17 December 2014

Roads and Maritime Reference: SYD14/00776/02(A8157043)
Council Ref: SSD6603

SITE 68 MIXED USE DEVELOPMENT, SYDNEY OLYMPIC PARK SSD 6603

M.D. 15.09.2014

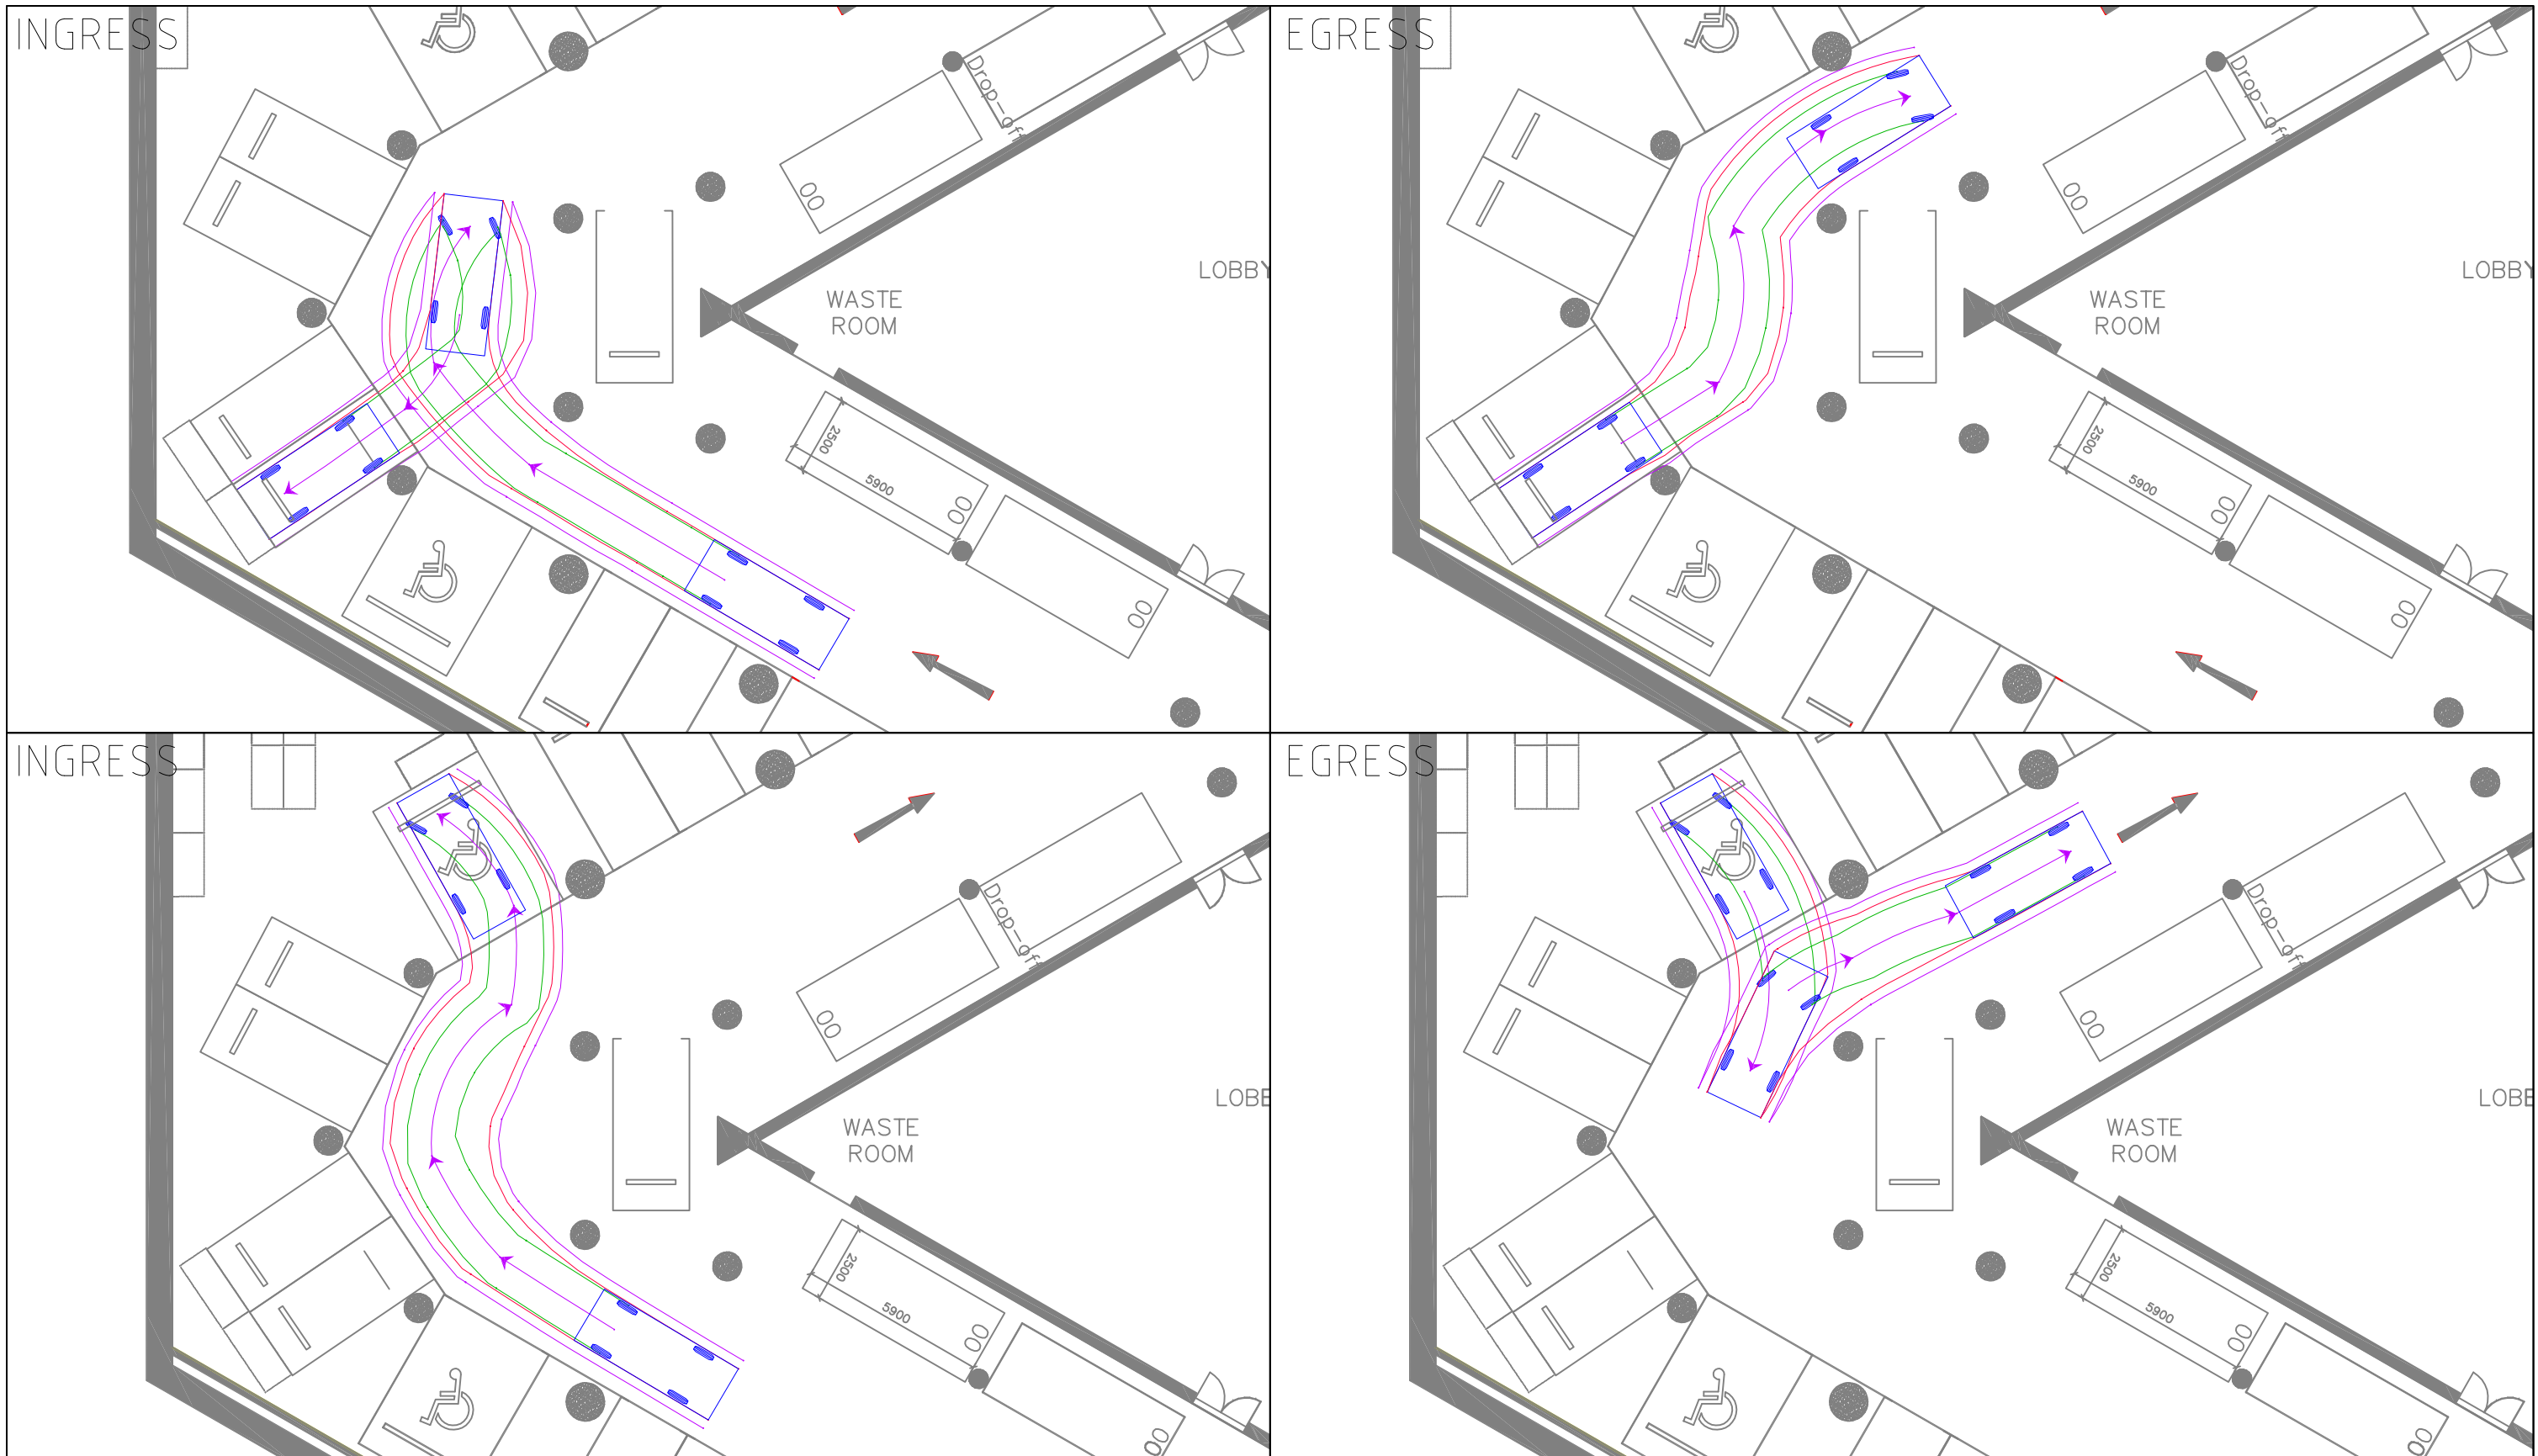
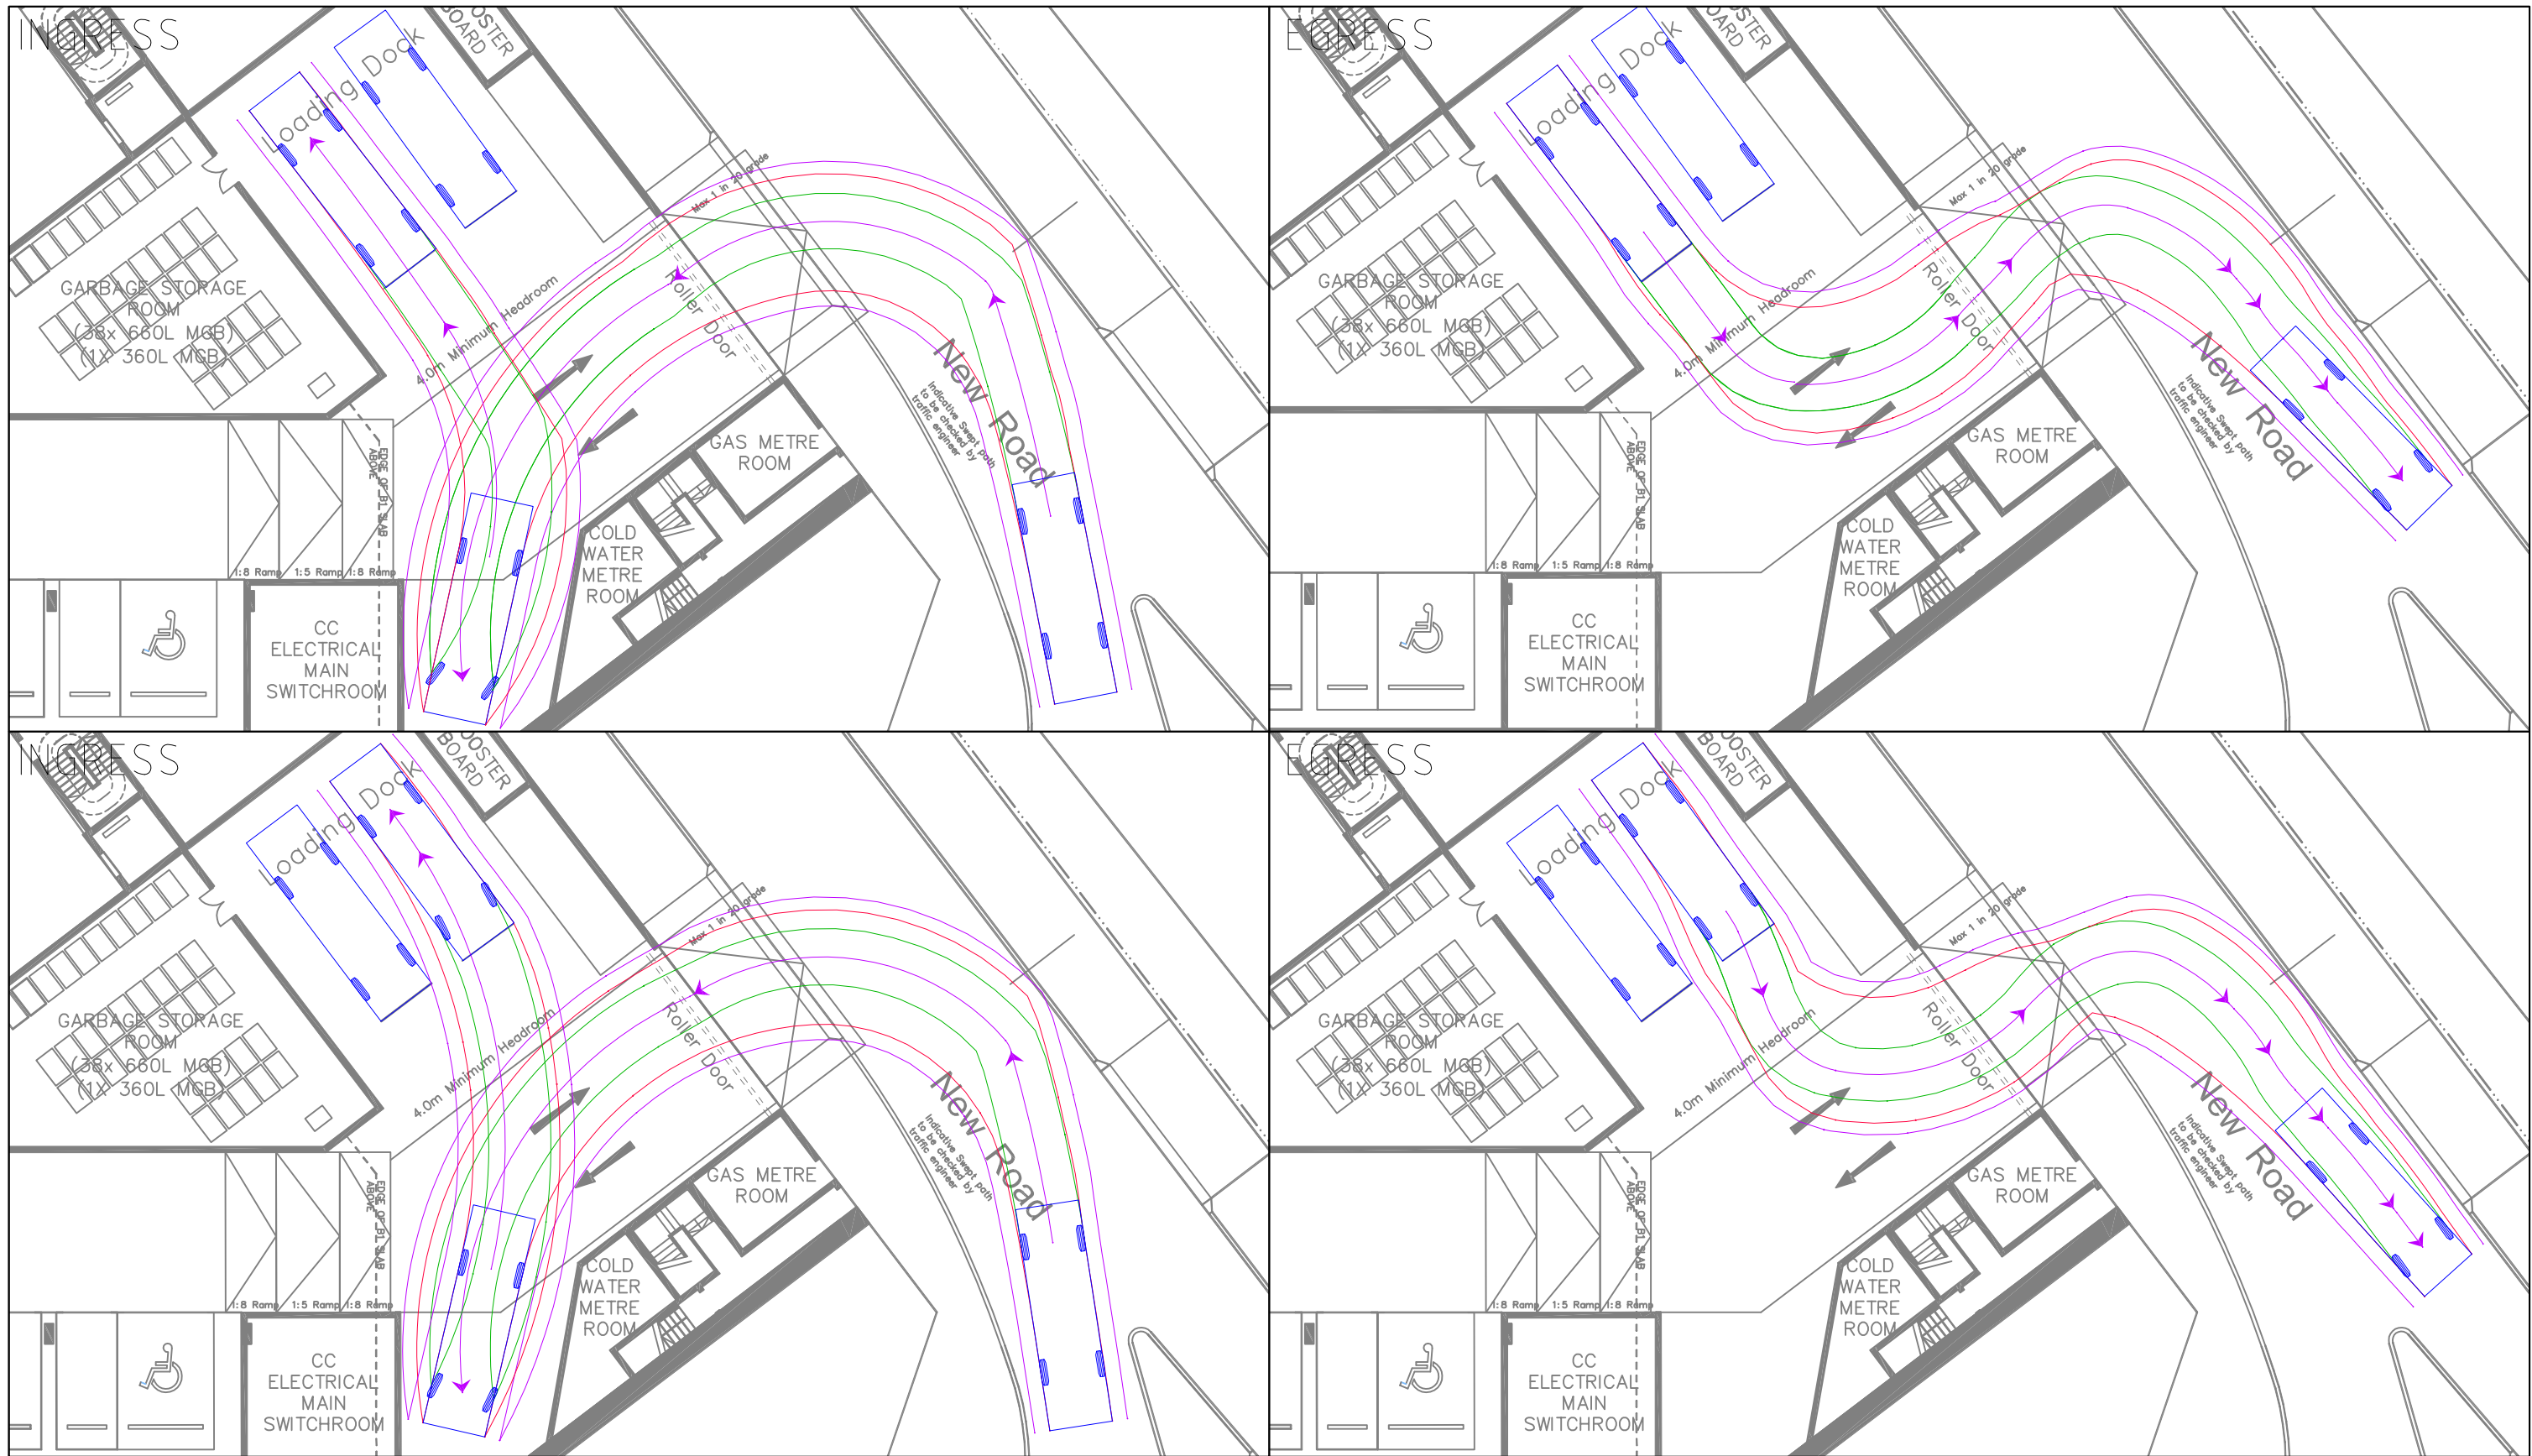
1. The proposed development at Site 68 shall comply with the approved Sydney Olympic Park Master Plan 2030.
2. The layout of the proposed car parking areas, loading docks and access driveway associated with the subject development (including, driveways, grades, turn paths, sight distance requirements, aisle widths, aisle lengths, and parking bay dimensions) should be in accordance with AS 2890.1- 2004 and AS 2890.2 – 2002 for heavy vehicle usage.
3. A Construction Traffic Management Plan detailing construction vehicle routes, number of trucks, hours of operation, access arrangements and traffic control should be submitted to Department prior to the issue of a construction certificate.
